Our ref: P680020-FRA L04
 Your ref: 21/02286/F

Re: Construction of a coffee unit with drive-thru facility and indoor seating with associated access, car parking, landscaping and servicing parking. Land North West of Launton Road roundabout adjoining Skimmingdish Lane, Caversfield

Please find attached a copy of the updated Flood Risk Assessment for the above application site. This letter and associated FRA report has been produced to reflect the consultation responses from the Environment Agency (dated 2nd September 2022, Environment Agency Ref: WA/2021/129266/04-L03) and our replies and updates since the original submission included as Section 4 of the FRA (680020-R1(03)-FRA, October 2022).

Title FLOOD VOLUMES SECTIONS 2 OF 3

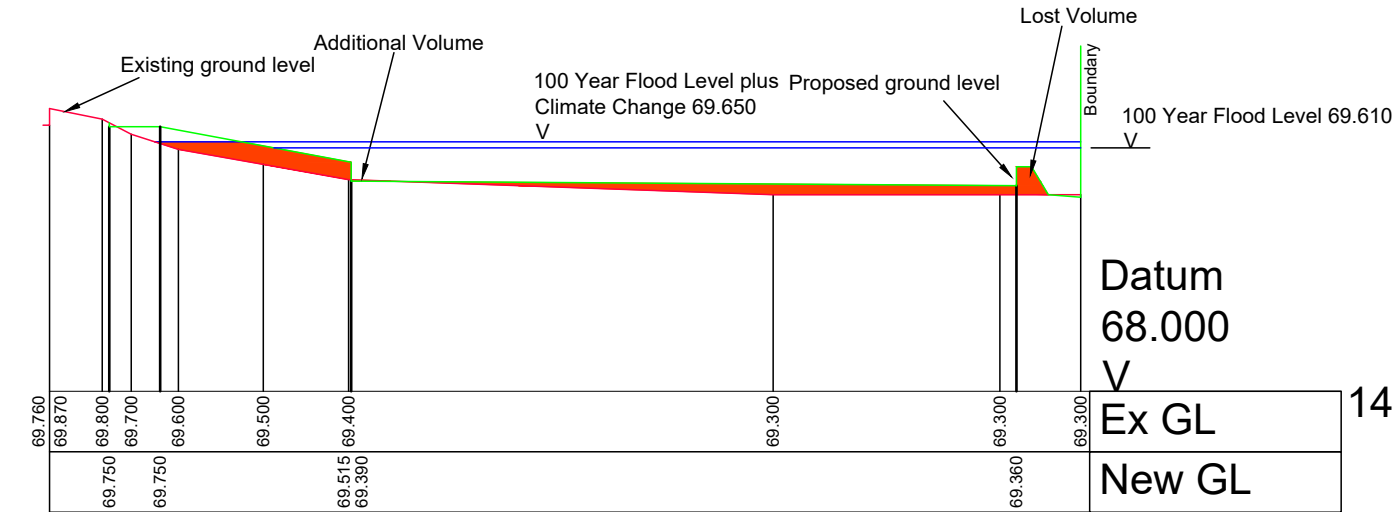
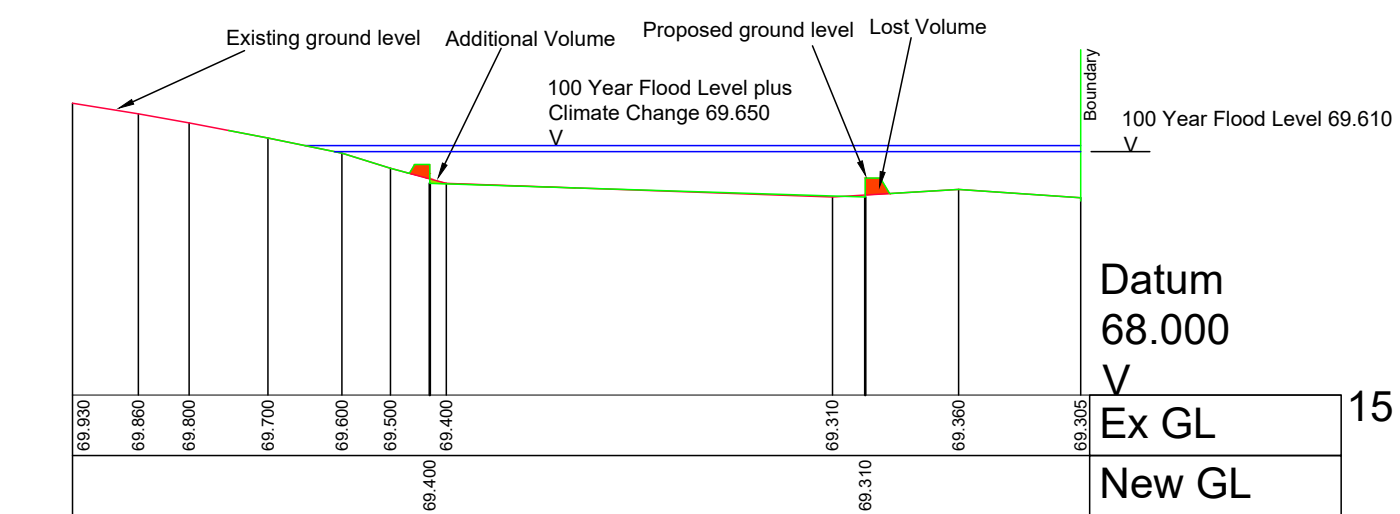
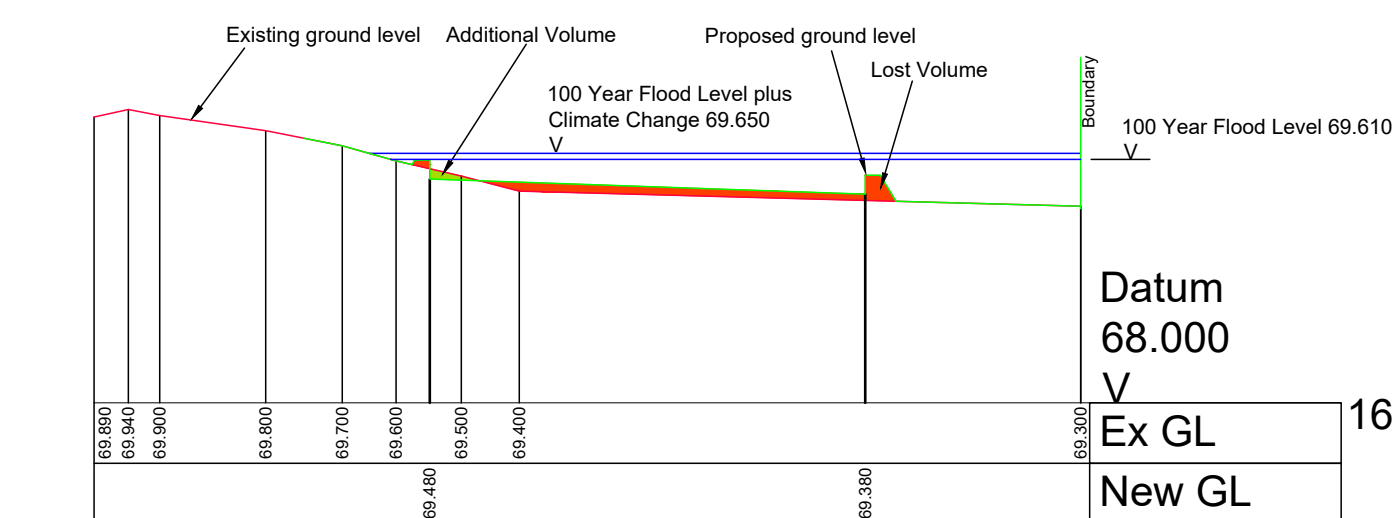
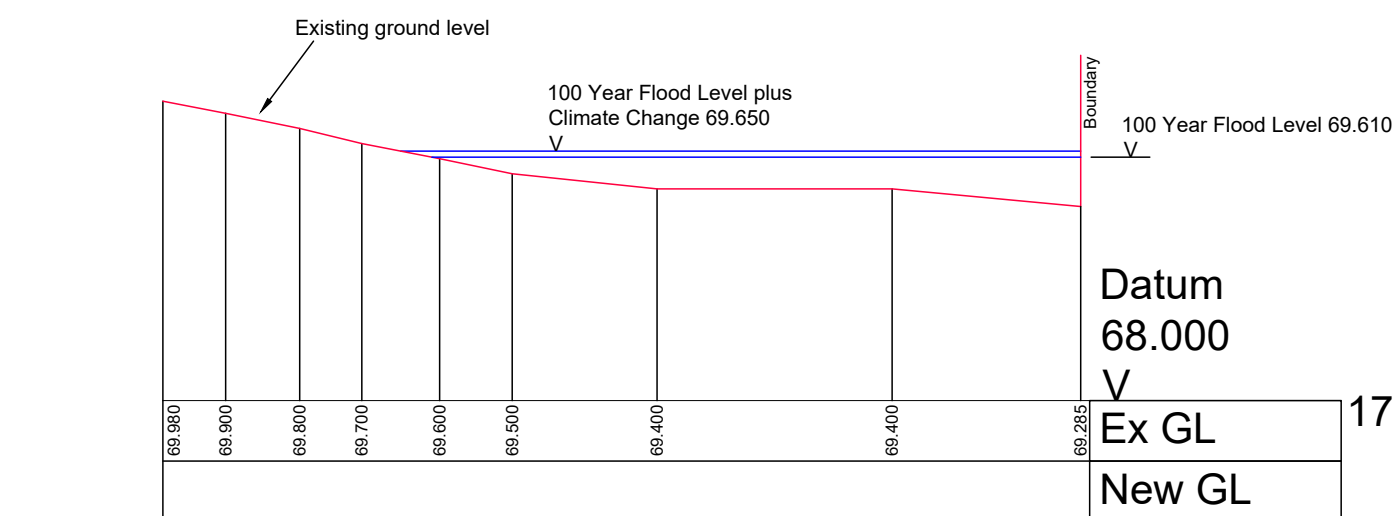
<p>It is still difficult to understand if the scheme would be hydraulically connected. For example, from comparing the spreadsheet values and the Layout Plan, it appears that the 2.88m³ of proposed volume between 69.16-69.26mAOD on the main development site would not be accessed until a flood level of approximately 69.30-69.33mAOD is reached. No commentary on this has been provided, but it appears that sufficient compensation is provided for this lowest slice (69.16-69.26mAOD) by lowering areas of raised land outside the main development site as shown on the Flood Volumes Section Layout Plan. We request</p>	<p>Drawing reference 220029_FV100_P7 and 220029_FV107_P3 (Extract below) show the site and the wider area floodplain offset and gain. The blue areas show where additional floodplain volume is created and the red where levels have been raised and volume is offset.</p>

Environment Agency Comment	RSK Response
<p>that further clarity is provided on this and how the compensation is hydraulically linked at other levels/slices.</p> <p>This can be shown by including plan/s which clearly mark the extents of each compensation slice so we can visually see how they are hydraulically connected. These extents should be based on the exact areas the applicant is lowering for each slice. It is not possible to view the individual compensation slices in the applicant's submitted plans.</p>	 <p>It can be seen from the spreadsheet that for each 100mm increment between 69.09m AOD and 69.69m AOD there is additional floodplain storage, once the flood level reaches 69.69m AOD, there is a displacement of floodplain for this 100mm increment, hence the requirement for additional attenuation at this level – in the form of the storage tanks.</p> <p>The level for level compensation is being provided in the underground tanks with the inlets set at the required level to provide the level for level compensation and allows for hydraulic connectivity to the floodplain when the flood levels reach these inlets (see above extract). It can also be seen from the cross sections that the flood levels enter the car park, so whilst there is some displaced floodplain volume in some areas, there remains a hydraulic connectivity between all sections of the site and the flood zone, therefore the plans and associated calculations show a true representation of the situation.</p> <p>It can be seen from the spreadsheet and the associated additional attention tanks that at all flood level increments, there is an increase in floodplain volume as a result of the development.</p> <p>In terms of hydraulic connectivity, the flood extent in the area encompasses the site, therefore any displaced volume in this location will retain a hydraulic connectivity to the flood plain and the watercourse either by the way of overland flow through the car park or by way of the drainage system.</p>

The individual plans outlined below contain the relevant cross sections throughout the development. The plans and the associated spreadsheet (below) clearly illustrate the impact of the scheme with respect to the flood compensation at the site.

Environment Agency Comment	RSK Response
	<p>A slice by slice plan would not add significant detail above and beyond the plans submitted as up to the level of 69.49mAOD there is a surplus of 105m³ storage created as a result of the scheme, with the levels from 69.49mAOD to 69.69mAOD accommodated within the flood compensation tanks.</p> <p>The following plans have been provided to with respect to the compensation plans (included as Appendix L of the FRA)</p> <p>Drawing 220029/FV100_P7 FLOOD VOLUMES SECTION LAYOUT PLAN.</p> <p>Drawing 220029/FV101_P9, FLOOD VOLUMES SECTIONS 1 OF 3</p> <p>Drawing 220029/FV102_P9, FLOOD VOLUMES SECTIONS 2 OF 3</p> <p>Drawing 220029/FV103_P9, FLOOD VOLUMES SECTIONS 3 OF 3</p> <p>Drawing 220029/FV105_P4, SECTION 13</p> <p>Drawing 220029_FV107_P3, Site Plan</p>
	<p>The appended spreadsheet (Bicester Flood Volume Calculations Flood Level 69.69 as included in Appendix L of the FRA) details the volumes to be attenuated and created at 0.1m 'segments'.</p> <p>It can be seen from the attached drawings and the associated spreadsheet that the level for level volume of flood water to be offset due to the development, if unmitigated, is 27.55m³ but only when flood levels range from 69.49mAOD to 69.69mAOD. It is this volume (27.55m³) that will be offset and attenuated in the tank system, offering the required level for level flood compensation as previously agreed. As stated above, the scheme will offer 30m³, of attenuation in the tanks, thus offering additional flood risk benefits of the scheme.</p> <p>Whilst the EA's requirement is for level for level compensation, there is an additional floodplain volumetric benefit from the scheme where there is a net gain in floodplain volume by 105.23m³ up to a flood level of 69.49mAOD (see table below) and it's when</p>

<p>*Positive figures indicate flood volume to be attenuated.</p> <p>*Negative figures indicate an increase in flood compensation volume.</p> <p>For flood depths up to 69.49mAOD, the flood compensation strategy offers 105m³ of storage (increase in flood compensation volume as noted in above spreadsheet extract), with a further 8.2% surplus (as part of the attenuated flood compensation volume in the above spreadsheet extract) provided in the events up to the 100 year plus 6% climate change event (levels between 69.49,AOD and 69.69mAOD).</p> <p>The approach is in line with the current iteration of the NPPF and PPG.</p>	Total Volume Difference by level					Levels			Volume Difference (m3)	Notes	Top (m)	Bottom (m)	Height (m)	69.69	69.59	0.1	12.27	Displaced Flood Volume contained within tank	69.59	69.49	0.1	15.29	Displaced Flood Volume contained within tank	69.49	69.39	0.1	-47.62	Volume Gained	69.39	69.29	0.1	-47.08	Volume Gained	69.29	69.19	0.1	-10.22	Volume Gained	69.19	69.09	0.1	-0.31	Volume Gained
Total Volume Difference by level																																												
Levels			Volume Difference (m3)	Notes																																								
Top (m)	Bottom (m)	Height (m)																																										
69.69	69.59	0.1	12.27	Displaced Flood Volume contained within tank																																								
69.59	69.49	0.1	15.29	Displaced Flood Volume contained within tank																																								
69.49	69.39	0.1	-47.62	Volume Gained																																								
69.39	69.29	0.1	-47.08	Volume Gained																																								
69.29	69.19	0.1	-10.22	Volume Gained																																								
69.19	69.09	0.1	-0.31	Volume Gained																																								
It is our understanding that two storage tanks are proposed to provide compensation for the highest 'slice'. The inlets/openings to these tanks are proposed at 69.535 and 69.635mAOD, and it appears that each tank would have a 15m ³ capacity (total 30m ³). By setting the lower opening at 69.535m AOD, it appears this would provide mitigation for the 69.46-69.56mAOD slice, and not the 69.56-69.66mAOD slice where it is required. We request that the applicant provides clarification on why this is and discusses whether this should opening be raised.	See above, the tables on the spreadsheet and section drawings (Appendix L of the FRA) have been revised to reflect this with levels now raised to 69.69mAOD
